CITY OF ALBUQUERQUE

June 11, 2019

RE: **7212 Menaul NE**
Grading Plan Stamp Date: 5/28/19
Drainage File: H19D040

Based on the submittal received on 5/29/19, the grading plan cannot be approved until the following corrections are made:

<div>ENGINEER'S SEAL</div> <div></div> <div>6/19/19</div> <div>DAVID SOULE P.E. #14522</div>	7212 MENAUL	DRAWN BY WCUJ
	GRADING AND DRAINAGE PLAN	DATE 6-19-19
	 Rio Grande Engineering 1606 CENTRAL AVENUE SE SUITE 201 ALBUQUERQUE, NM 87106 (505) 872-0999	2108040-LAYOUT-5-10-19
		SHEET # JOB # 2109040

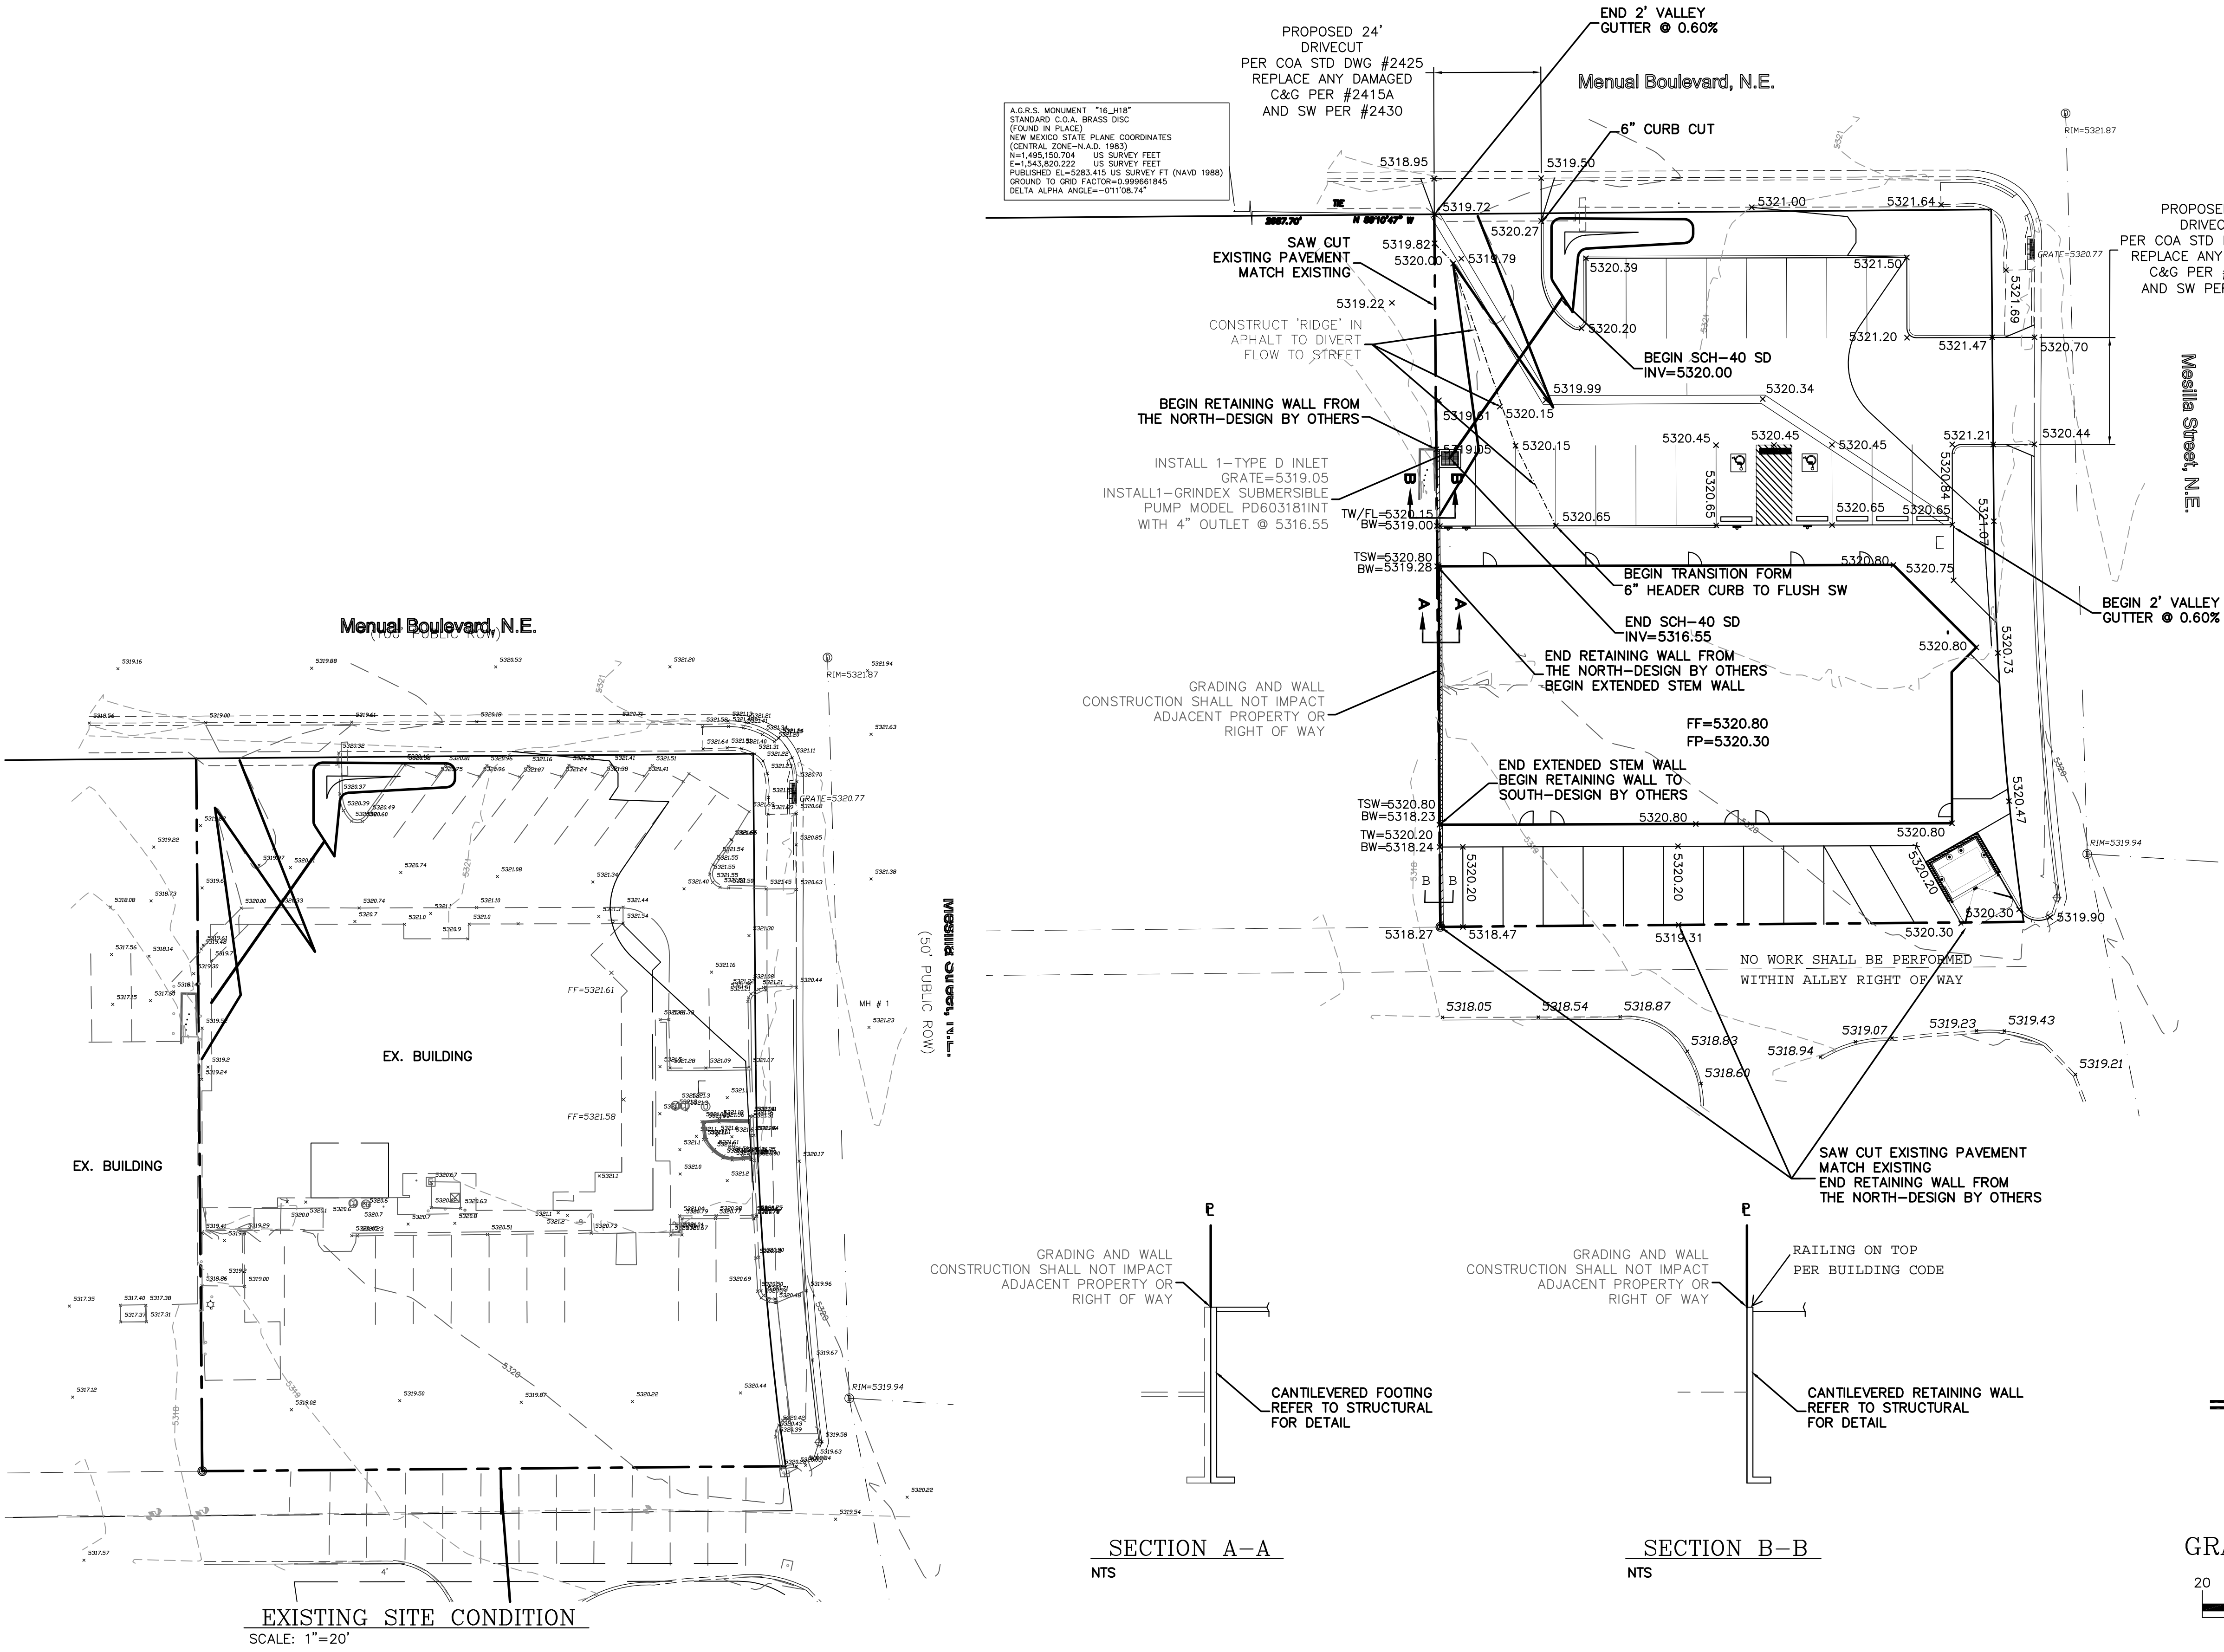
1. Show the grading and site work for repaving the alley.
2. Provide proposed contours and increase the density of existing and proposed spot elevation along the property line. Hydrology is especially interested in the tie-in to the alley and the property to the west.

3. Provide sections through the west property line showing proposed retaining walls, garden walls, property/ROW lines, existing and proposed grades. In accordance with DPM Ch.22, section 5 part B, grading and wall construction near the property line may not endanger adjacent property or constrain its use.

4. The note to end the valley gutter at the Manual entrance also says to begin a retaining wall. Will this cut-off access to the property to the west? Show the retaining wall location.

5. What is the building use? For trash enclosures serving food service developments, demonstrate *control of liquids from dumpster areas* per DPM Chapter 22.9.E, Table 1 by containing runoff from the dumpster area and discharging to the sanitary sewer. If this information is on the utility plan please provide it, or show on the grading plan.

6. Provide a Bernalillo County recorded drainage easement granted by the property owner to the west for discharging across their property, or modify the grading to eliminate cross lot drainage.
